Subject: Fowler Creek Guest Ranch Revised Application

I have reviewed the Revised Application for the Fowler Creek Guest Ranch dated 6-24-2024 and further modified by reducing the acreage from 84.3 acres to 34.9 acres. While the revised application has made some improvements, particularly by reducing the scope (removing rental cabins & residential habitats) and not using FS Rd 4517 for egress, many other items remain unchanged and the overall project remains detrimental with serious impacts to Traffic, Fire, Noise, Water, Safety and health, the environment, and to the peaceful character of this rural neighborhood.

FOWLER CREEK GUEST RANCH
EXHIBIT 12
EMERGENCY INGRESS AND EGRESS PLAN

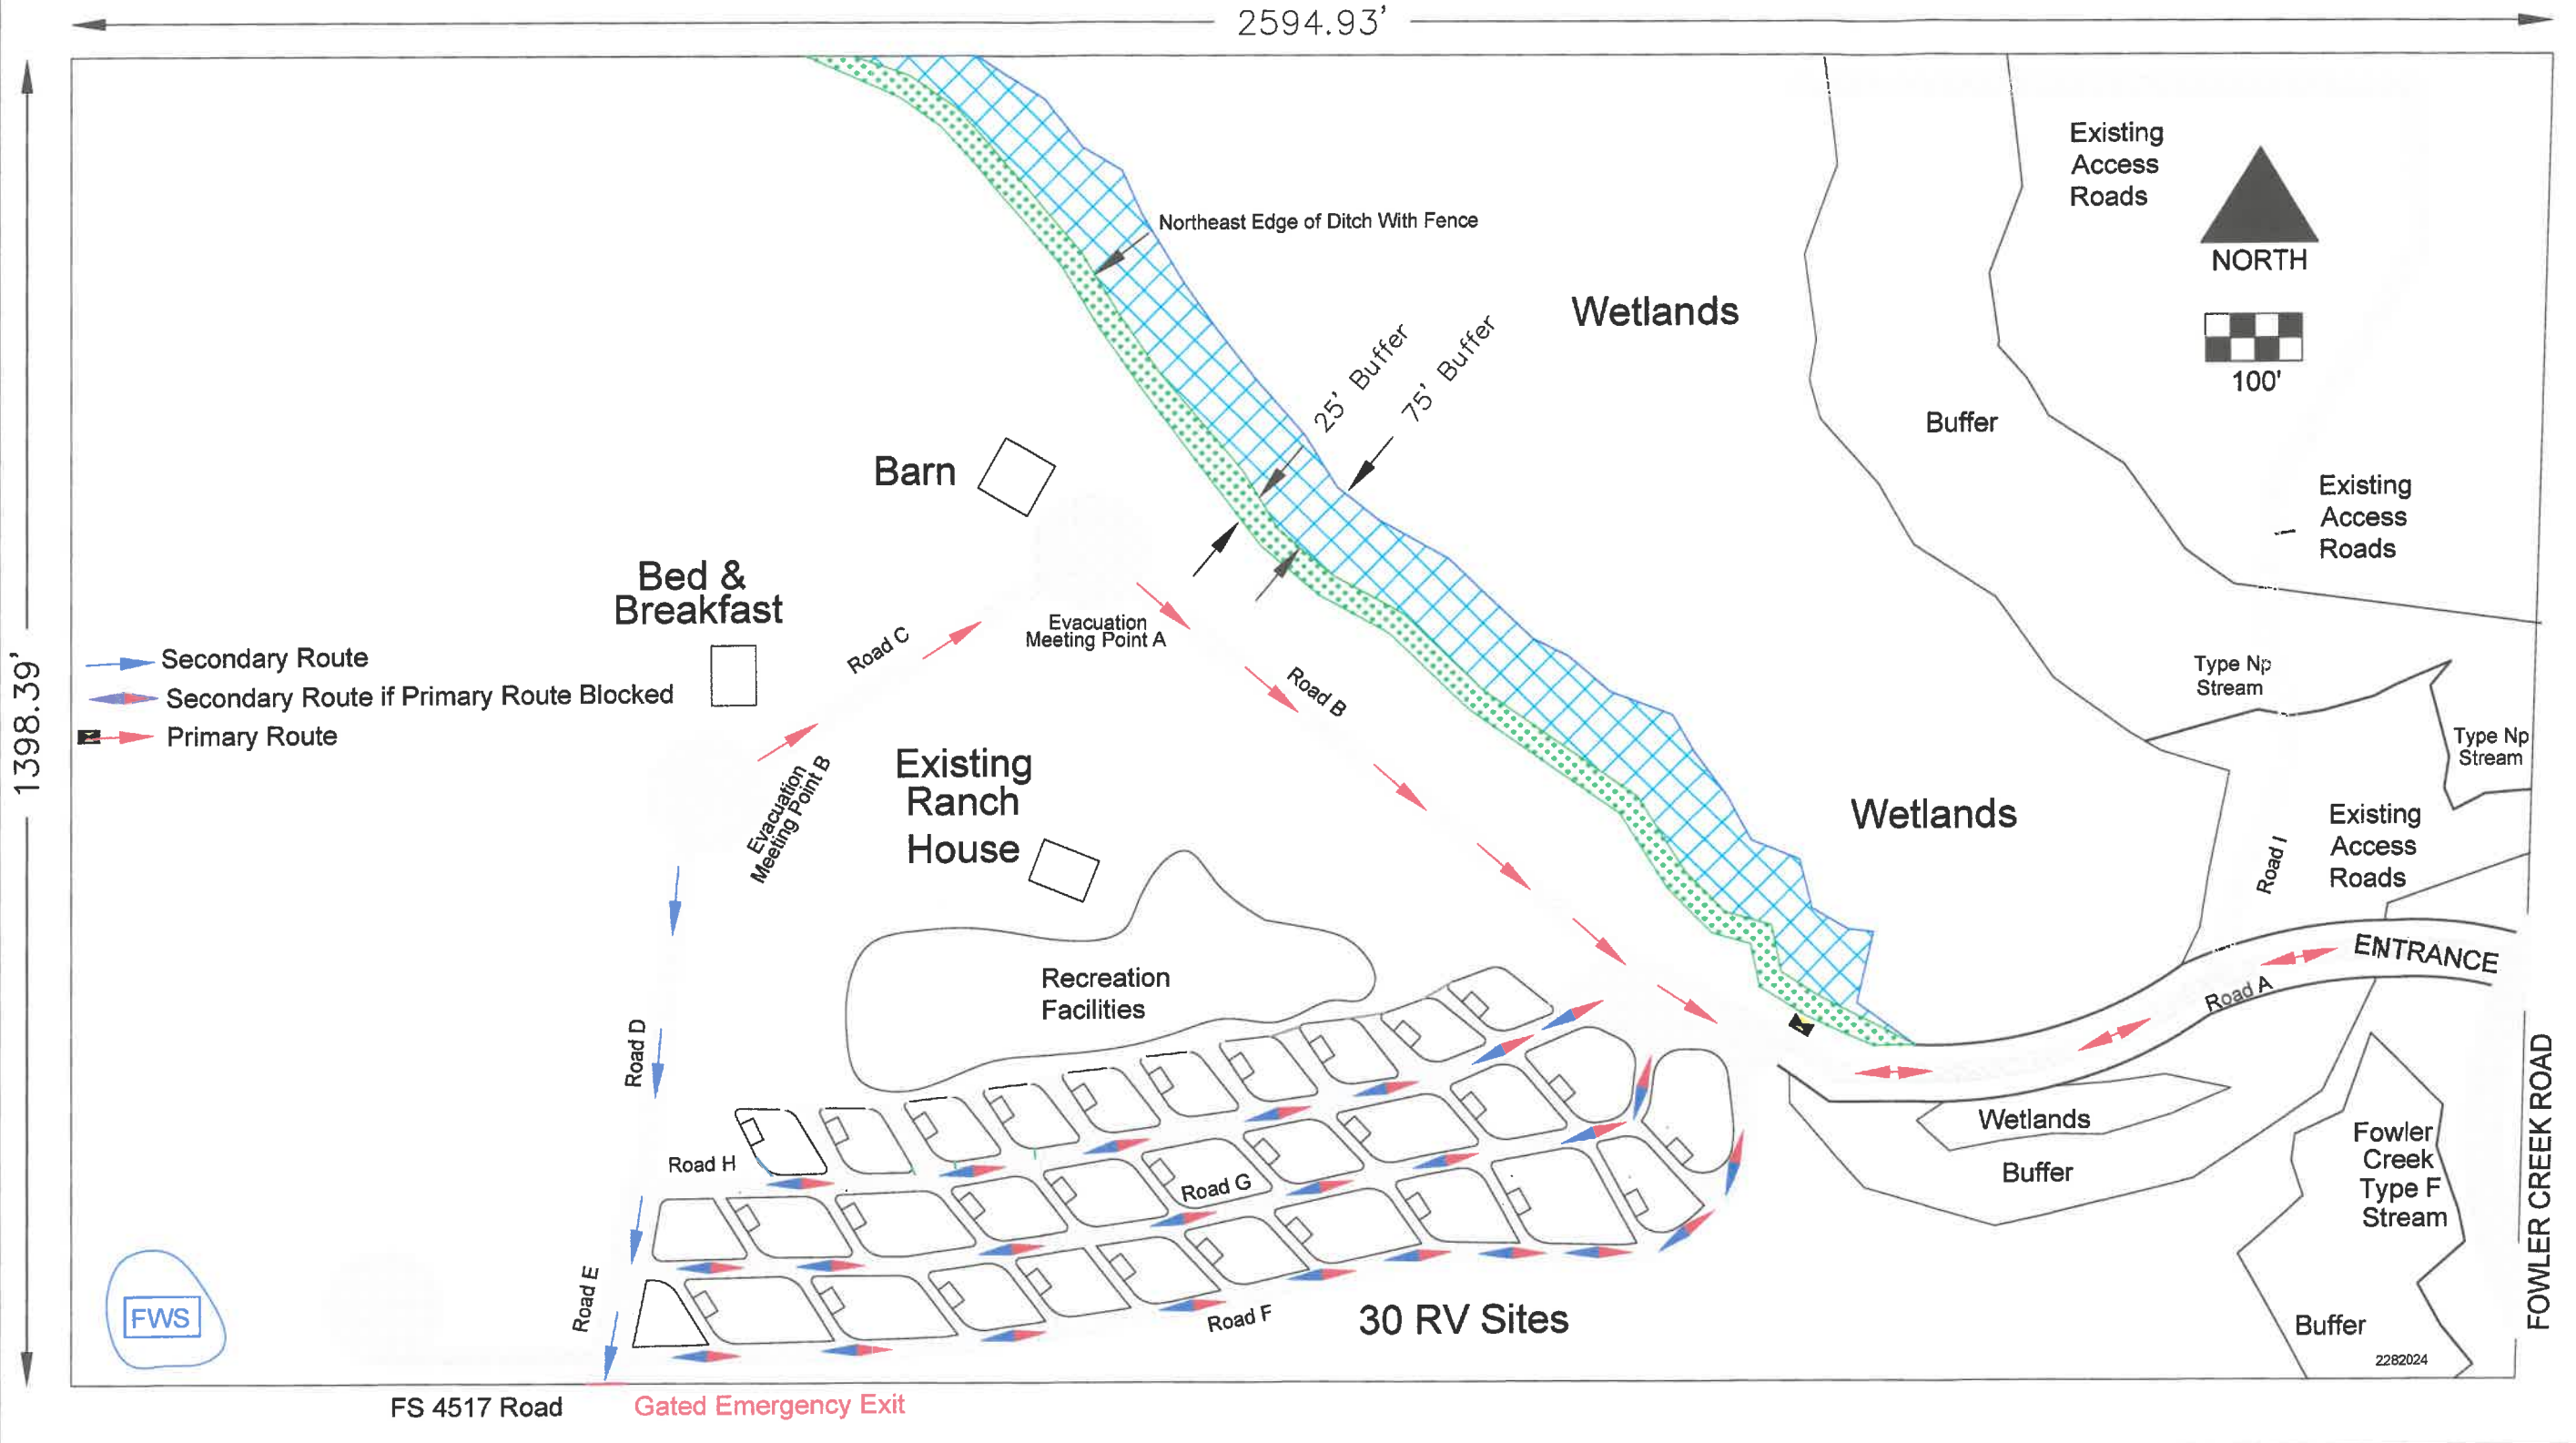
4. Exhibit 12 only considers getting people within the Guest Ranch out safely. They don’t consider that the number of people at their facility will make it impossible for community members to get out in time. Imagine if a fire started when they were at full capacity. They will have nearly 400 people at the guest ranch to evacuate down Fowler Creek Road. They will block people higher up or on Pasco Rd from getting out. And what is to prohibit people with RV’s from hooking up and trying to keep their RV from harms way, blocking the road, even if there is a rule against it? It’s a potentially very dangerous situation. With climate change, the situation will get riskier as the years go on. (Reference my Estimated Quantities on the attachment)
